Substantive response of the Local Highway Authority to a planning consultation received under The Development Management Order.

Planning Application Number: 23/0610/OUT

Application Address: Church Farm Station Road Elmesthorpe LE9 7SG

Outline application for residential development of three dwellings with associated infrastructure (layout, scale and means of access for approval)

SITE LOCATION & BLOCK PLANS

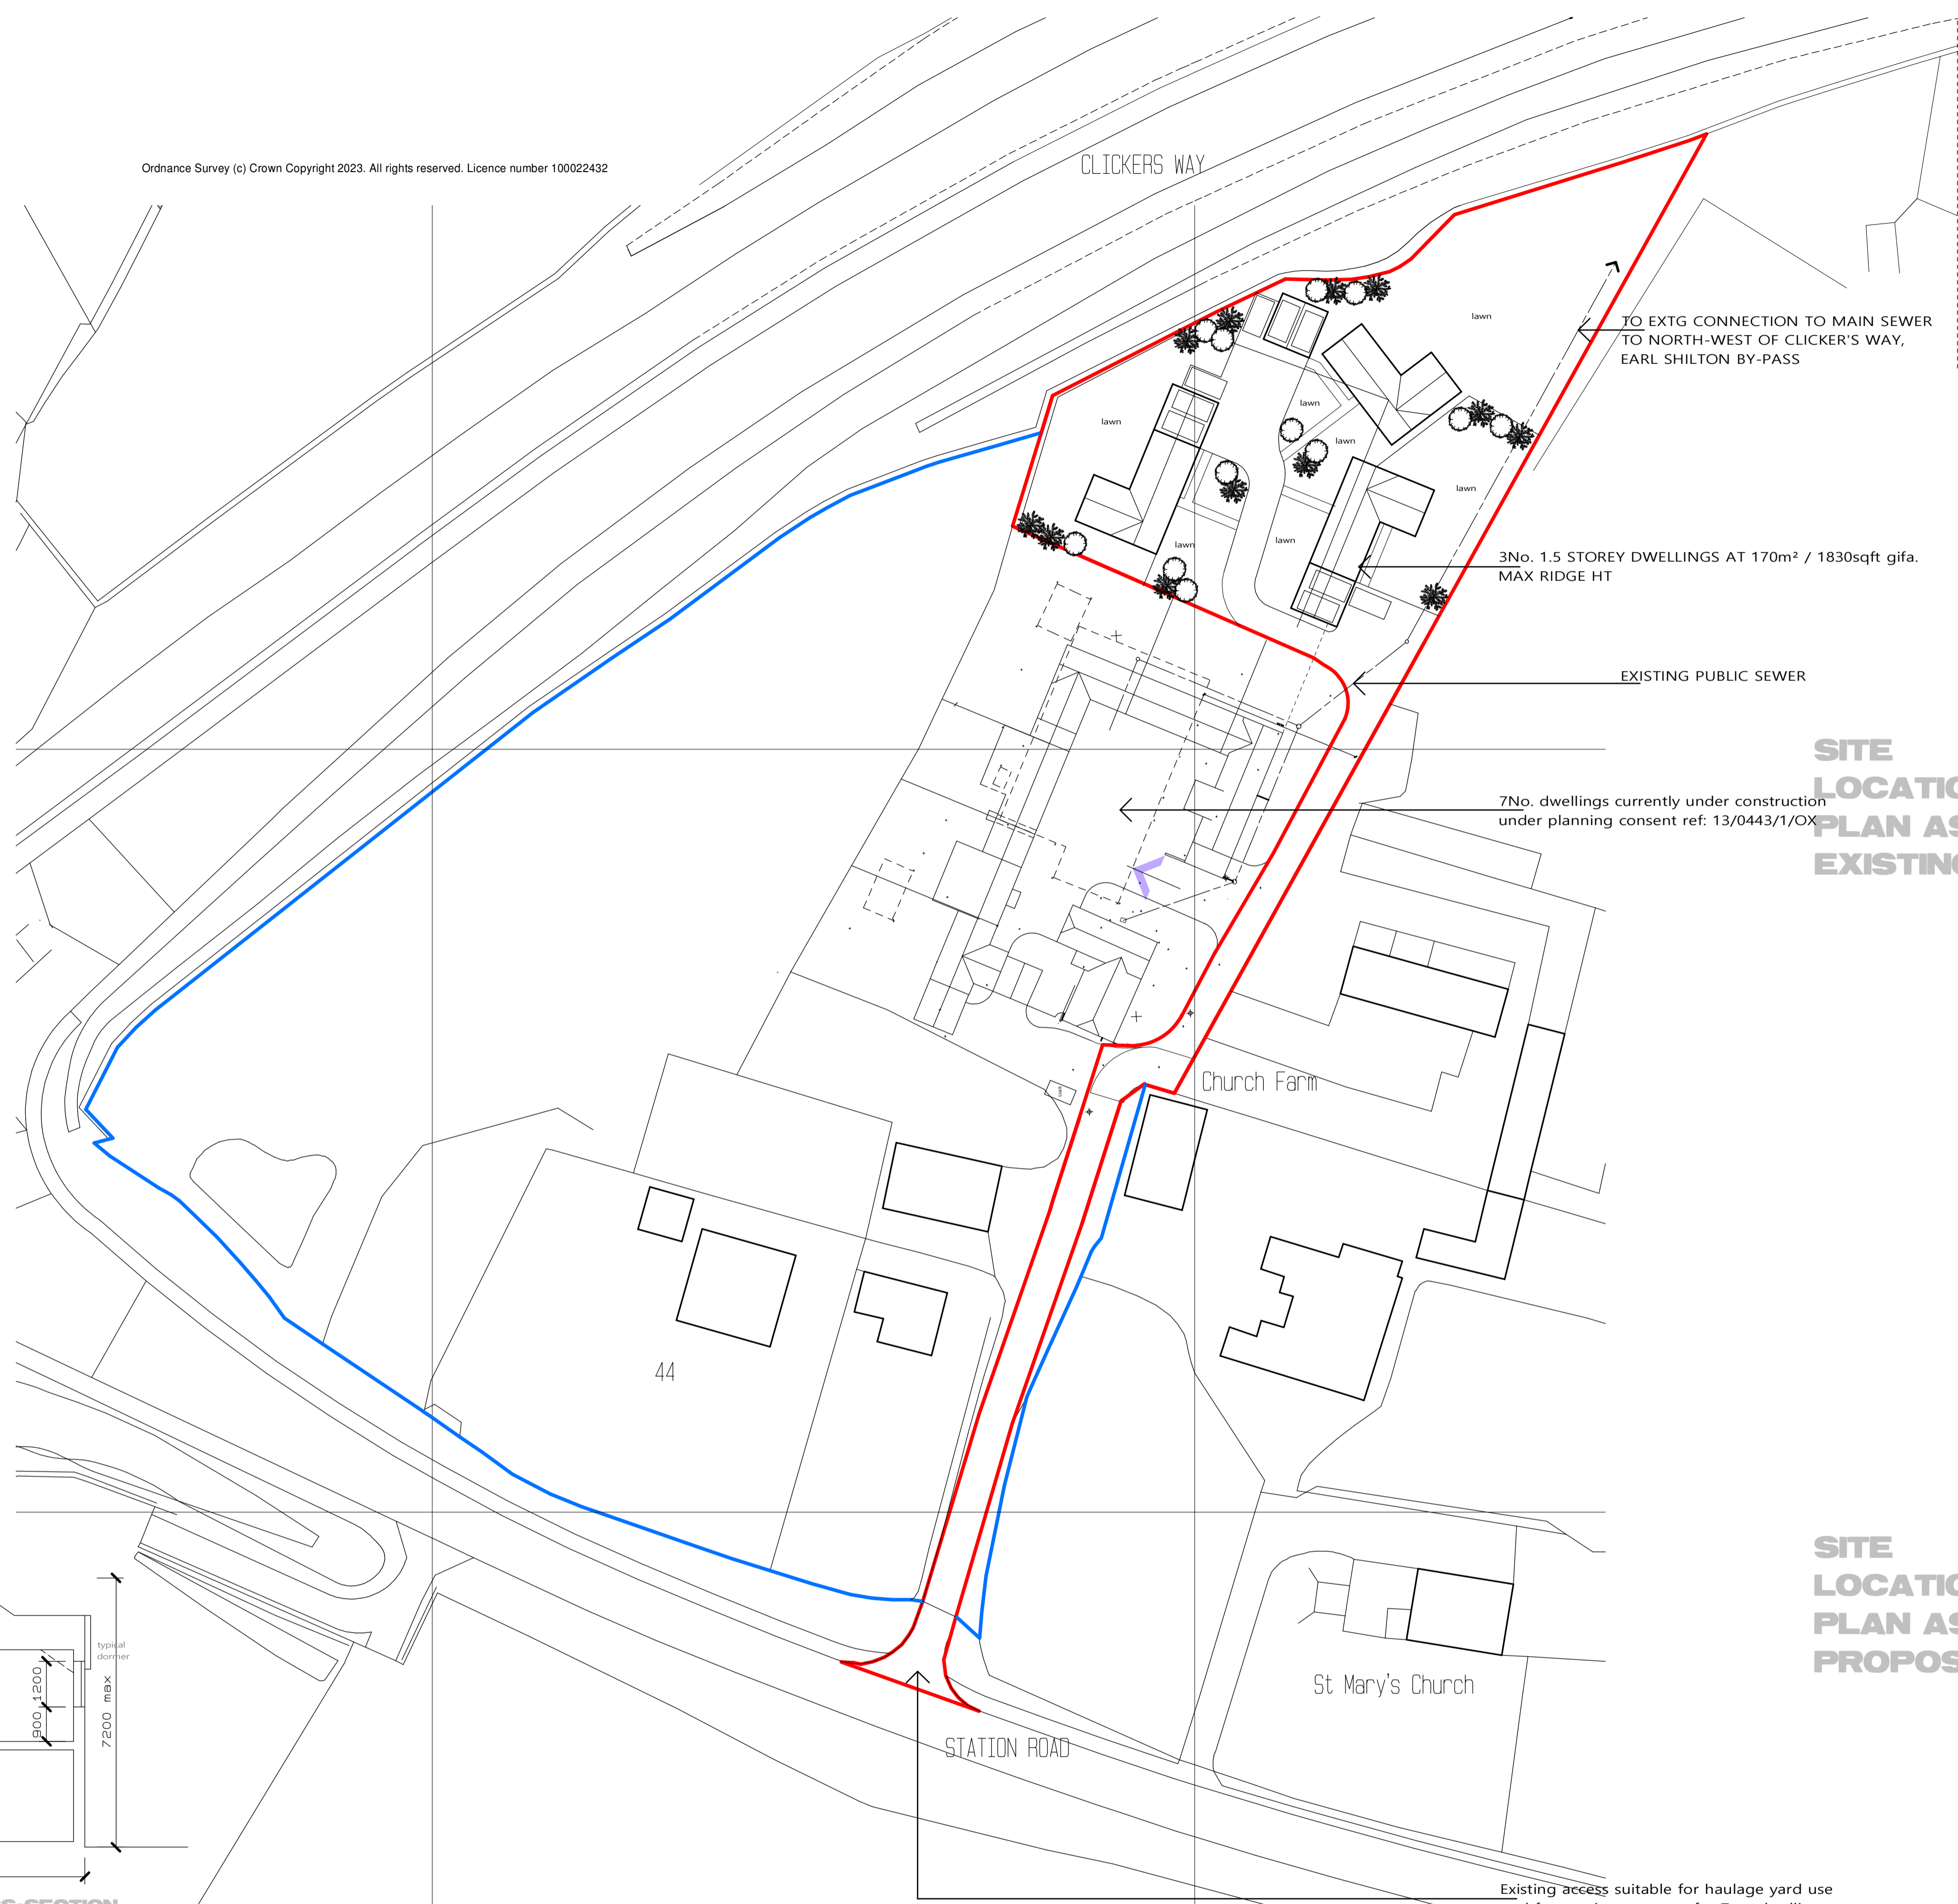
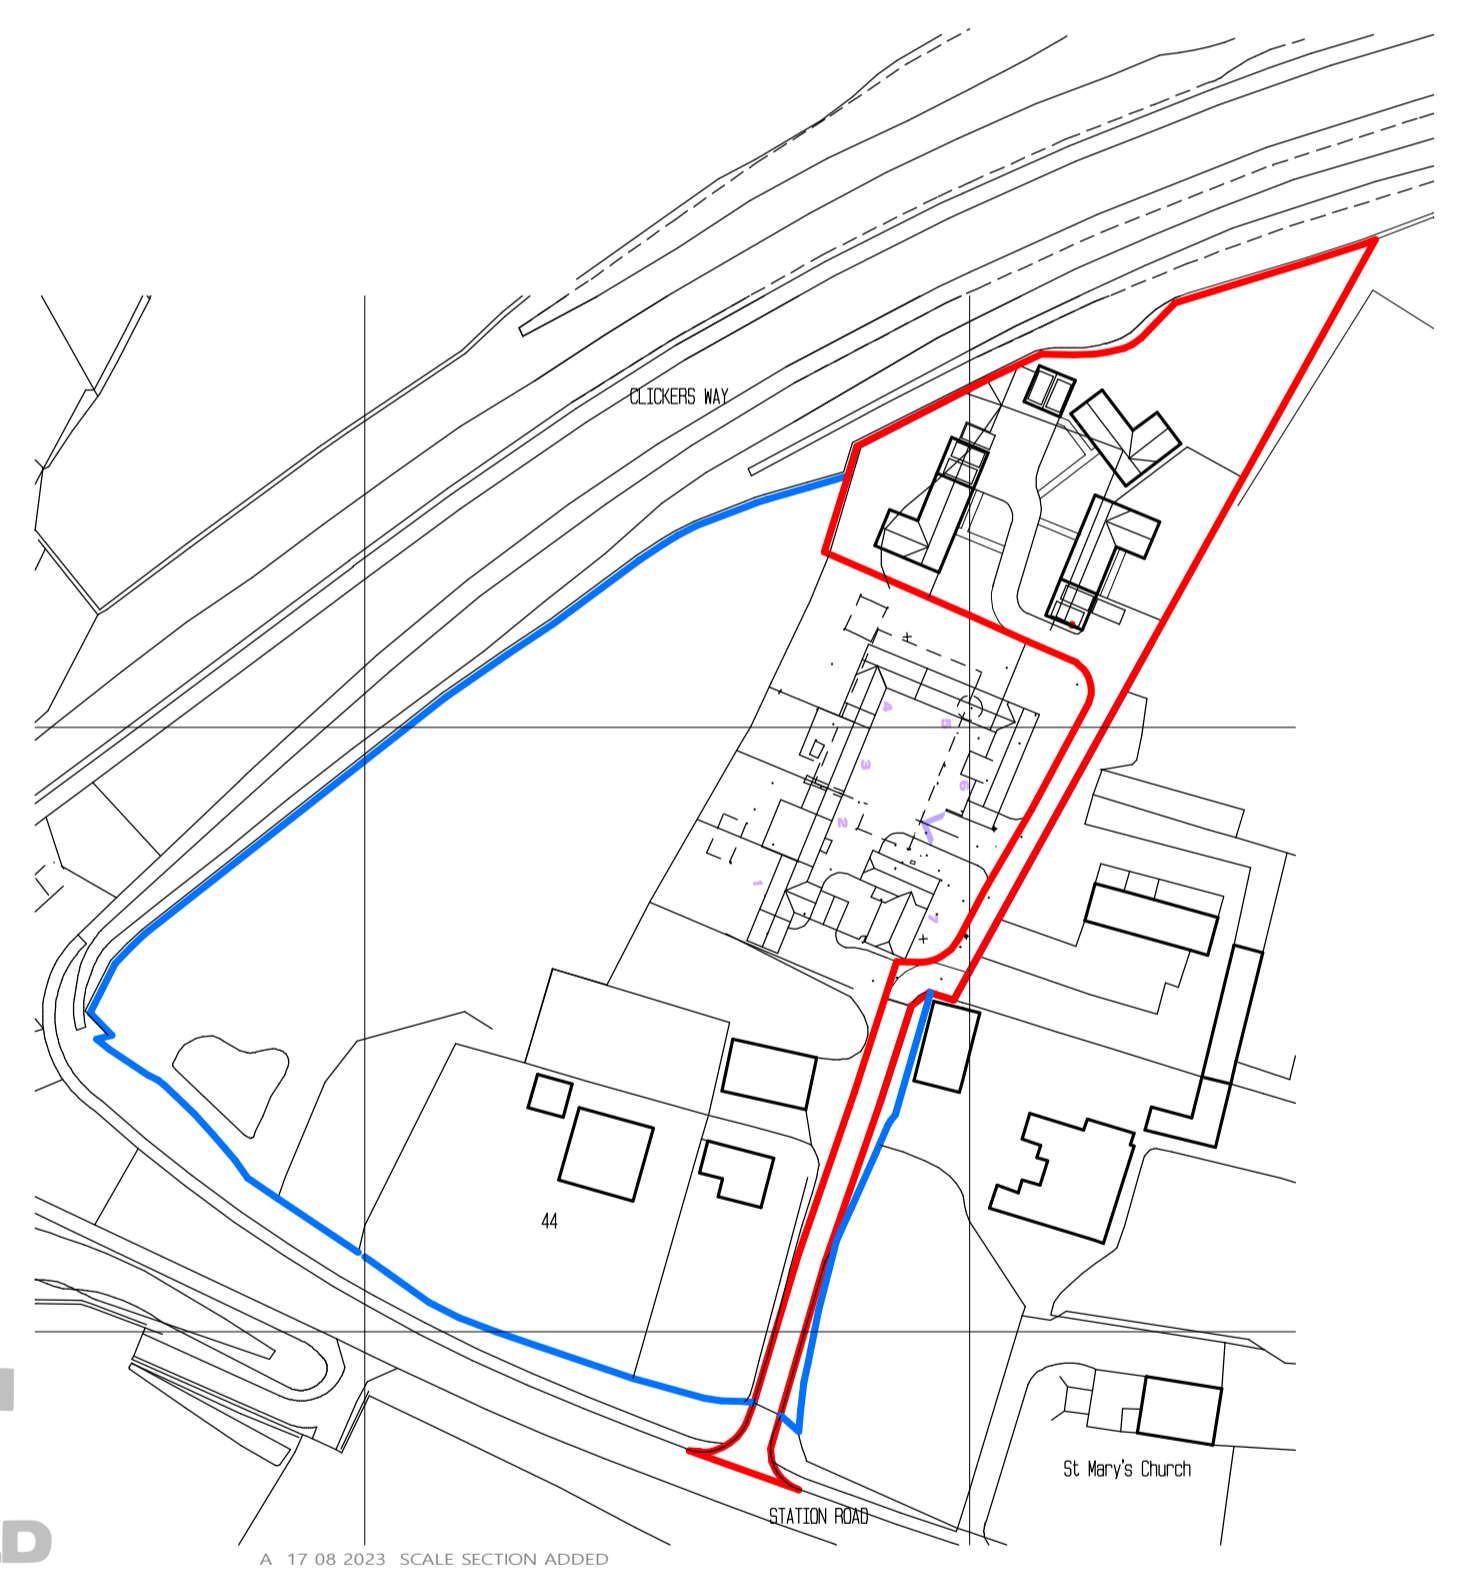
Access to the site is proposed via an existing point of access on to Station Road, a B classified road (B581) subject to a 40mph speed limit. No amendments are proposed to the site access, which was also accepted as part of application reference 17/1597/RM for seven dwellings to the

The LHA considers that given the current use of the site as a haulage yard, no further amendments are required and the existing access arrangements are acceptable.

The LHA have reviewed GBa&e drawing number 4017/2022/01 Rev A, and are satisfied that there is sufficient parking and turning space available for all three plots.

Given the scale of the proposed development, the LHA would not consider the internal road layout for adoption. Given the distance of the dwellings from the public highway, the Local Planning Authority may wish to consider how refuse collection would be undertaken from the site and access for fire appliances.

1. The development hereby permitted shall not be occupied until such time as the parking (and turning facilities) have been implemented in accordance with &GBa&e drawing number 4017/2022/01. Thereafter the onsite parking (and turning) provision shall be kept available for such use(s) in perpetuity.
